Address: 50 Virginia Road Huddersfield HD3 4AZ

Application number: 2021/93254	
What is the application for?:	Erection of single storey rear and two storey side extension
Address of the site or building:	52, Virginia Road, Marsh, Huddersfield, HD3 4AZ
Postcode:	HD3 4AZ

PROPOSED FIRST FLOOR PLAN

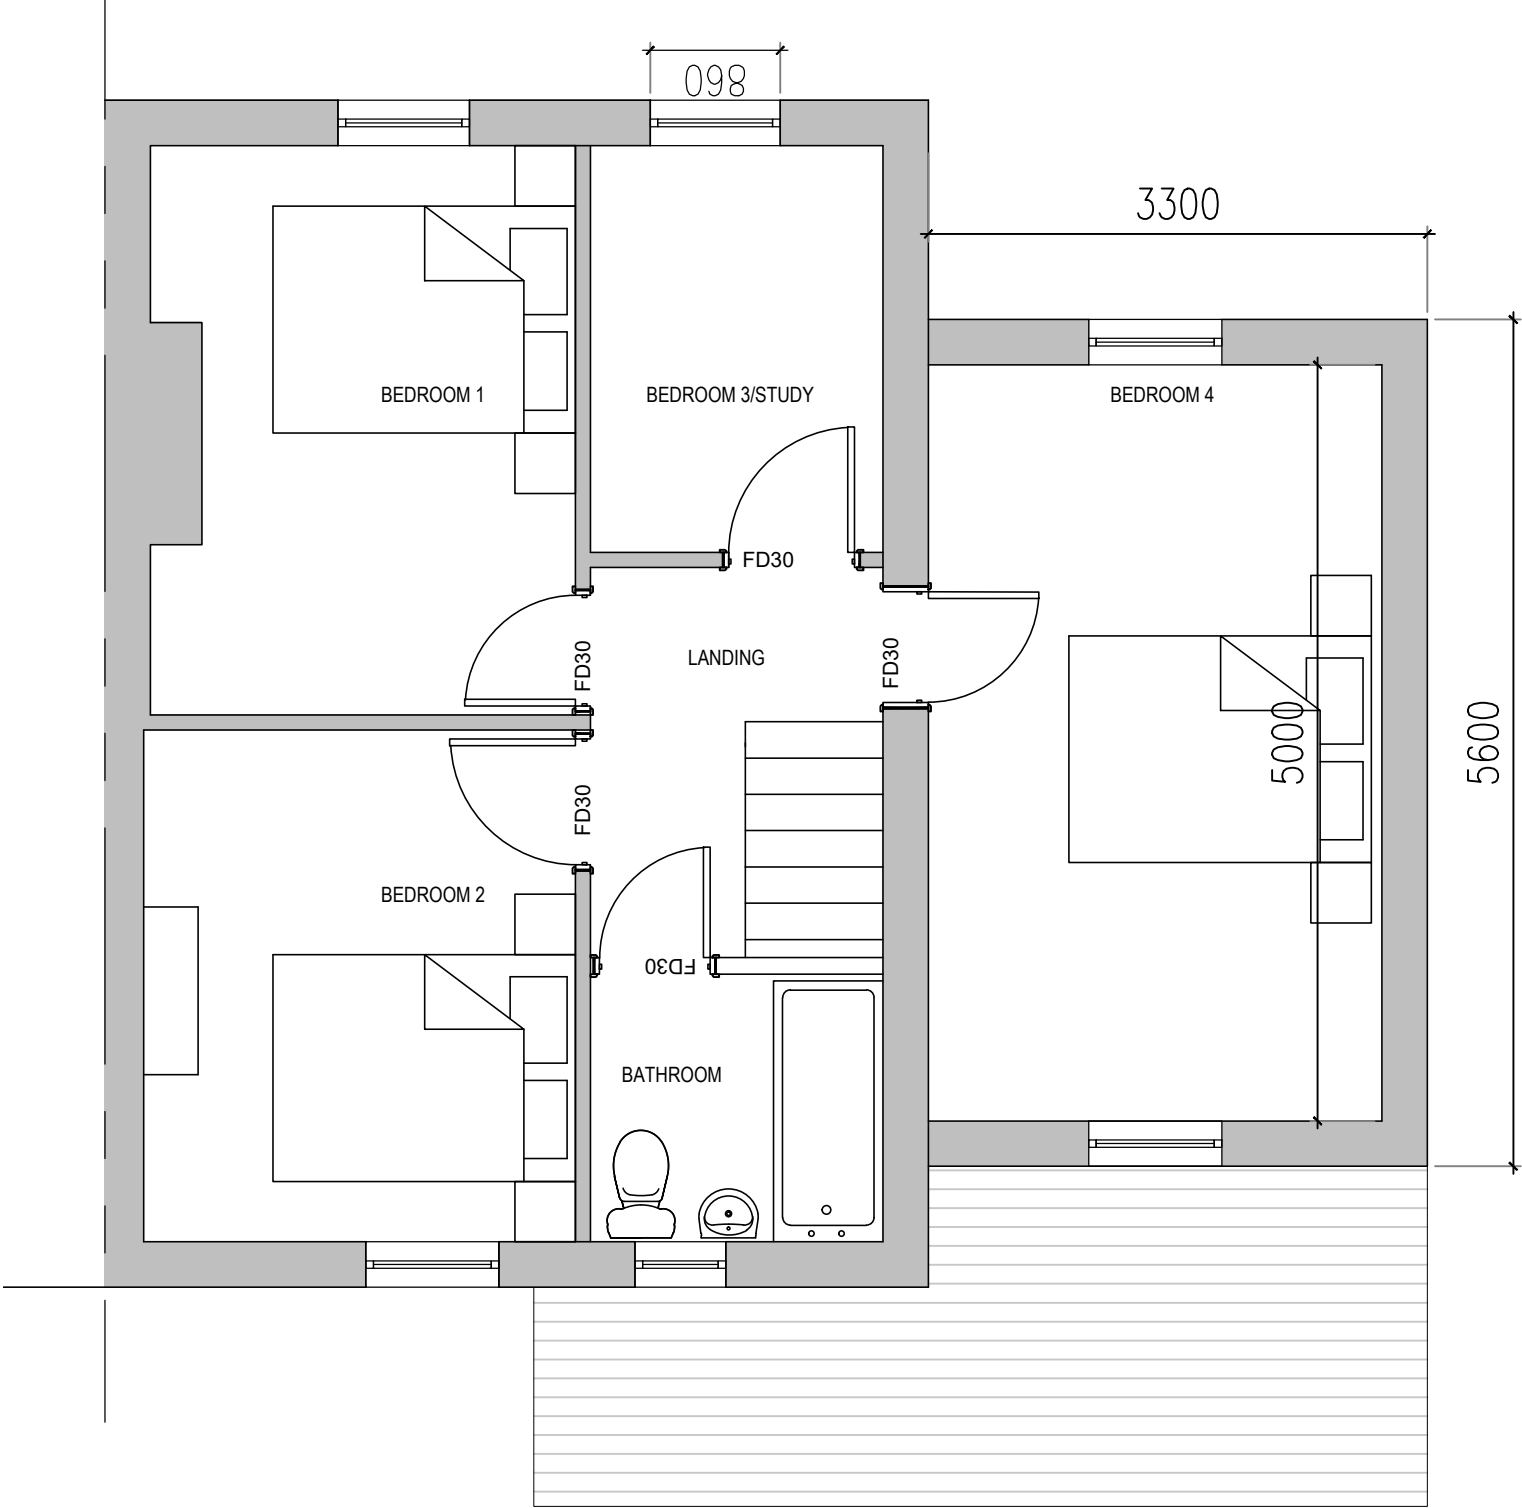
Type of comment: A general comment	
Do you wish your comments to be published on the website anonymously?	No
Doc 8899007 existing, the outside shed is visible. On proposed rear elevation shed is also visible. doc 889906 Proposed ground rear, shed is not visible. Also is not visible on proposed site block plan. This is a shared brick shed. I want assurances the shared shed will not be touched. On householder application page re trees; applicant has answered 'no' to tree or hedges within falling distance of 52 Virginia rd ,however there is a large sycamore tree on the property ,at the rear of 52 Virginia rd.
